**Consultation Response from KC,
Highways Development Management**

2023/93799 7, Inglewood Avenue, Birkby, Huddersfield, HD2 2DS

**Date Responded: 09/05/2024,
Responding Officer: D. Stainsby
Responding Ref: K5-3SE/17**

Project No. 2020
Enquiry 55
Project Title
proposed ground with dimension

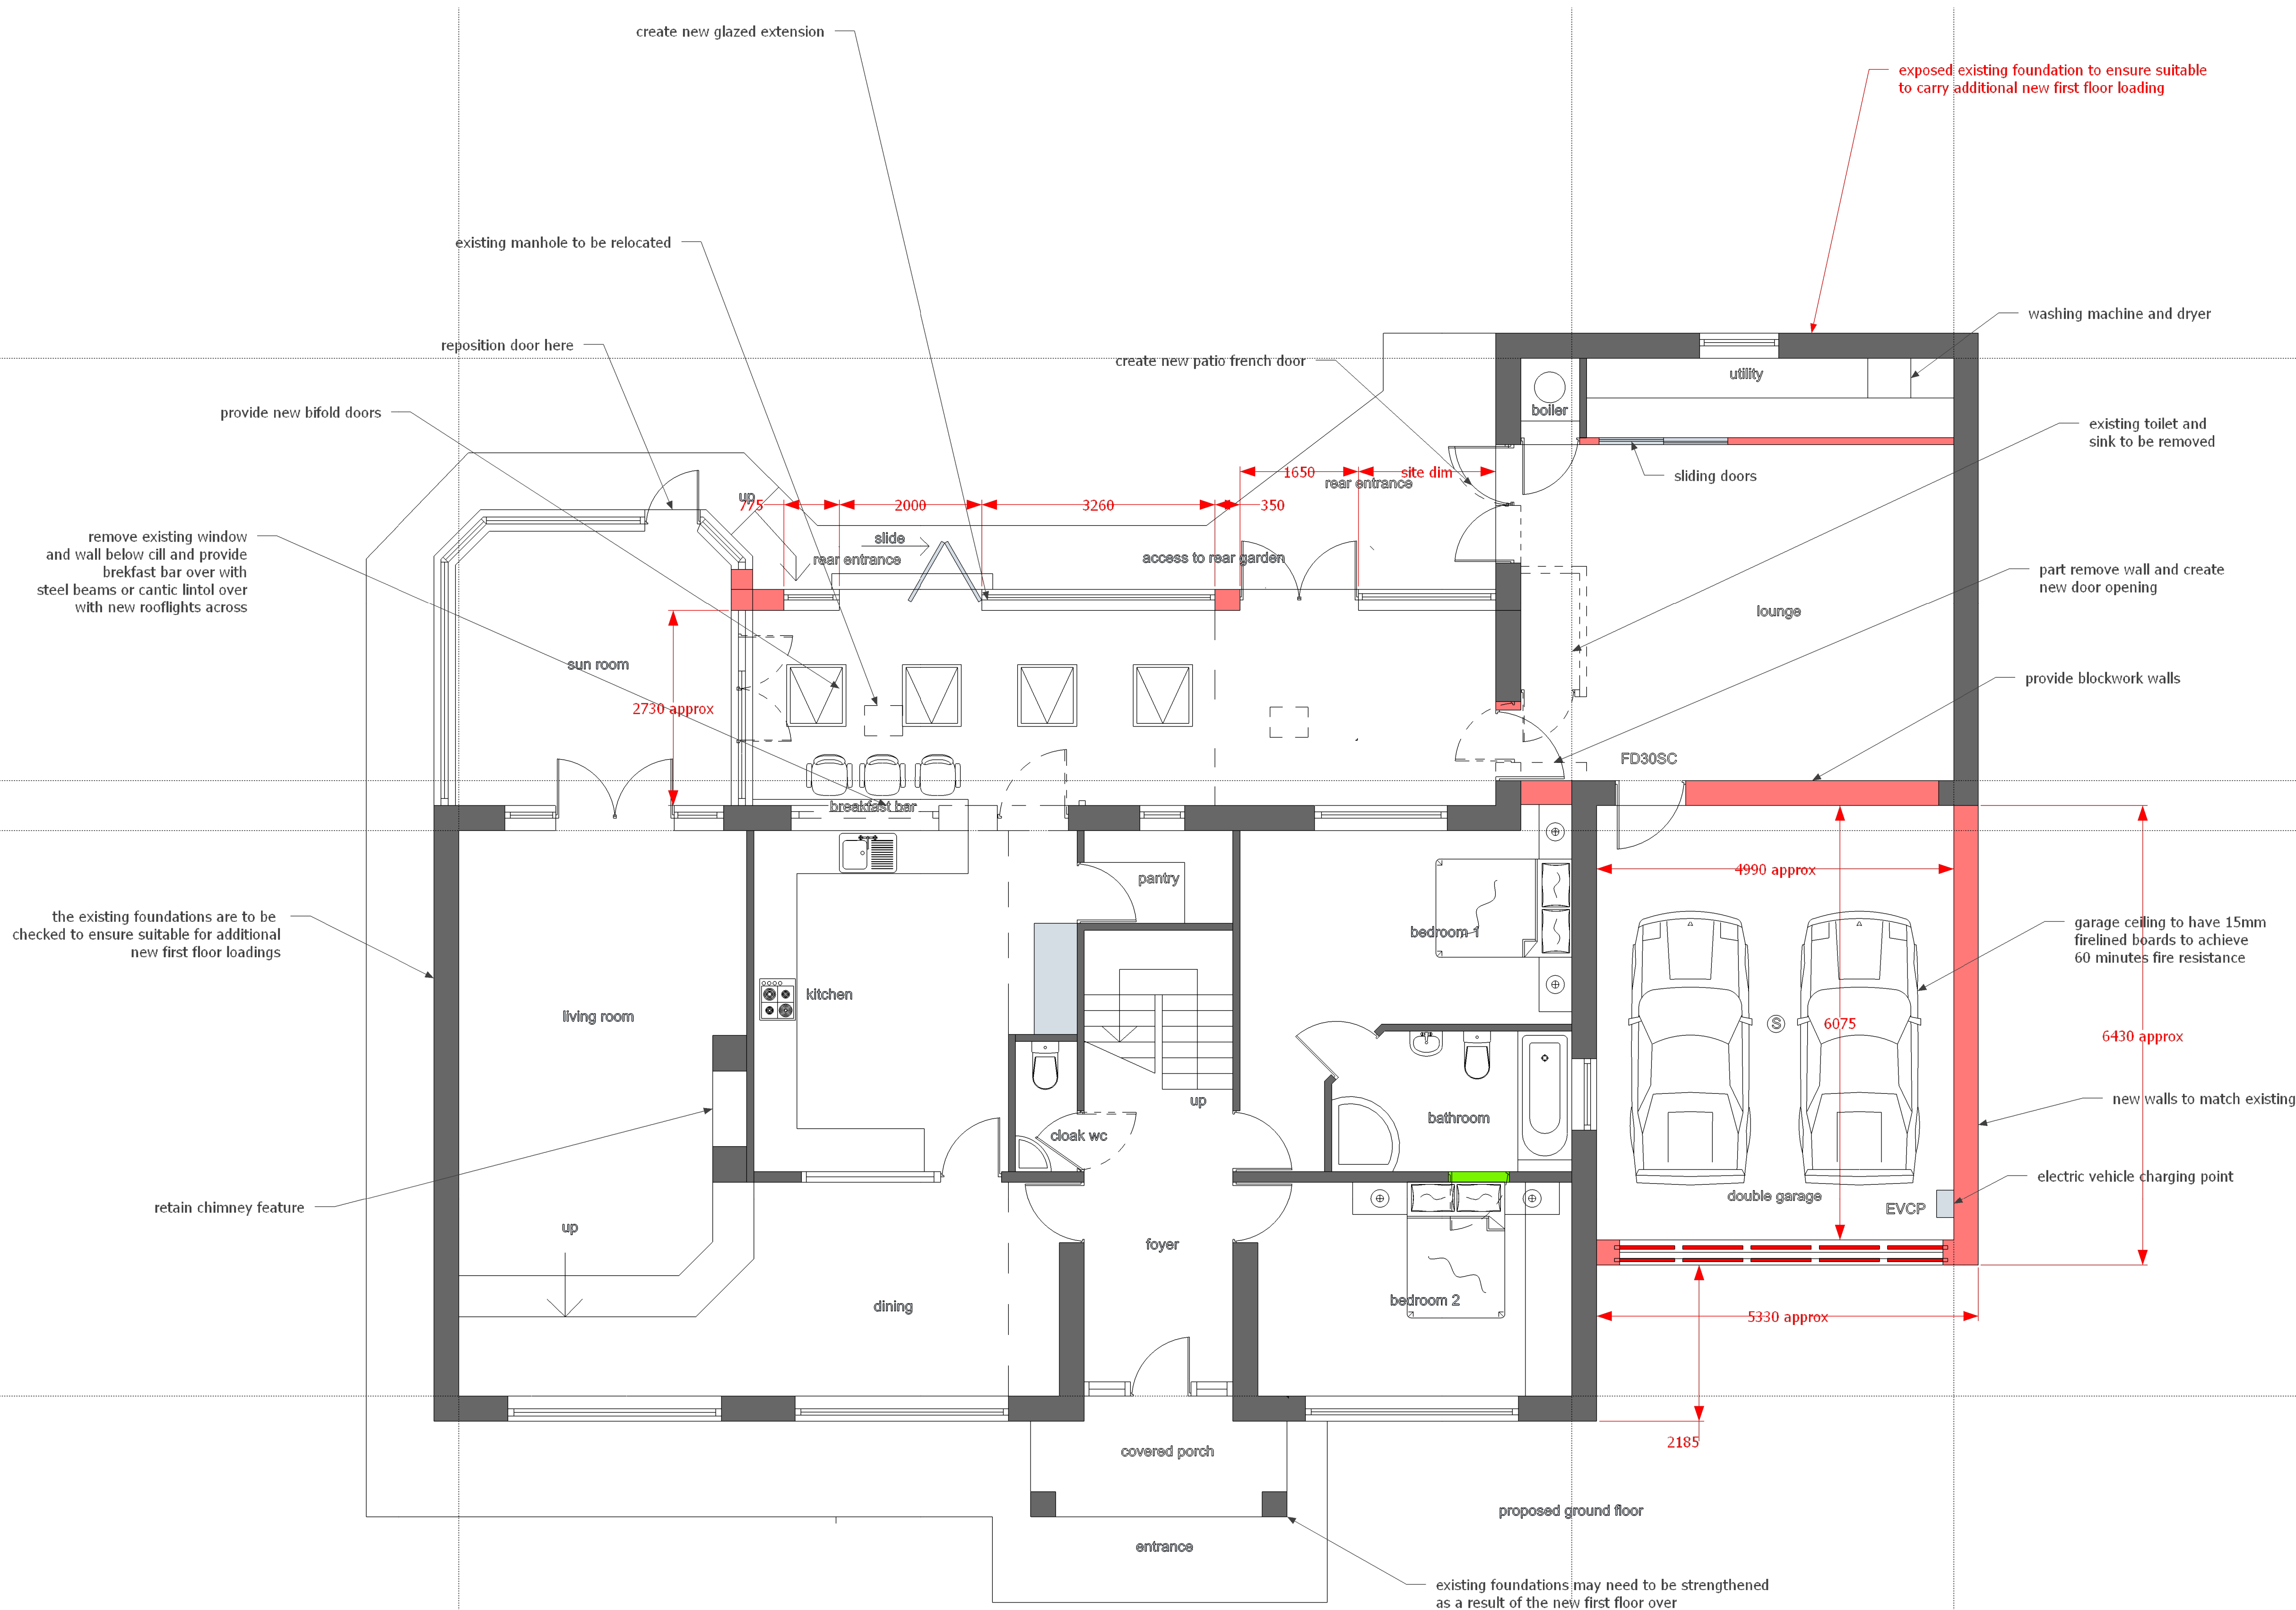
The proposed driveway uses the existing vehicle access to the site and parking is proposed for 4 vehicles which meets the guidelines for a 4+ bedroomed dwelling.

Internal turning has been proposed to ensure vehicles can enter and leave the site in forward gear,

This is acceptable in highway terms.

The approved vehicle parking areas will need to be surfaced and drained in accordance with the Communities and Local Government; and Environment Agencies 'Guidance on the permeable surfacing of front gardens (parking areas)' published 13th May 2009 (ISBN 9781409804864) as amended or superseded.
